Date: September 12, 2017

Subject: Restaurant Brewery Site I-25 SB-FRT MP-233.5  
Pasadena Ave and Venice Ave

SHEET TITLE: SITE PLAN FOR BUILDING PERMIT

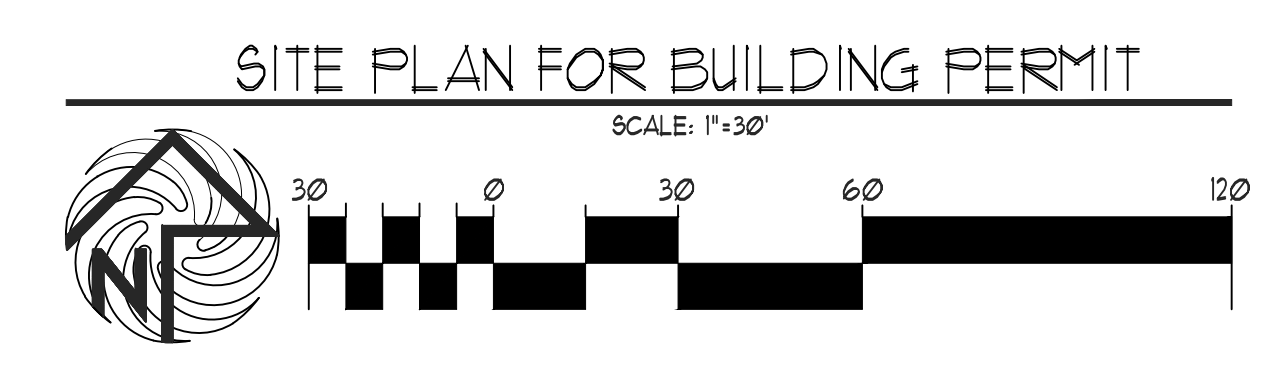
The NMDOT concurs with site plan BP-1 dated 8-4-2017. As indicated in the site plan **NO** direct access or pedestrian improvements (Sidewalk) will be required along I-25 southbound frontage located approximately at Milepost 233.5 between Pasadena Ave and Venice Ave.
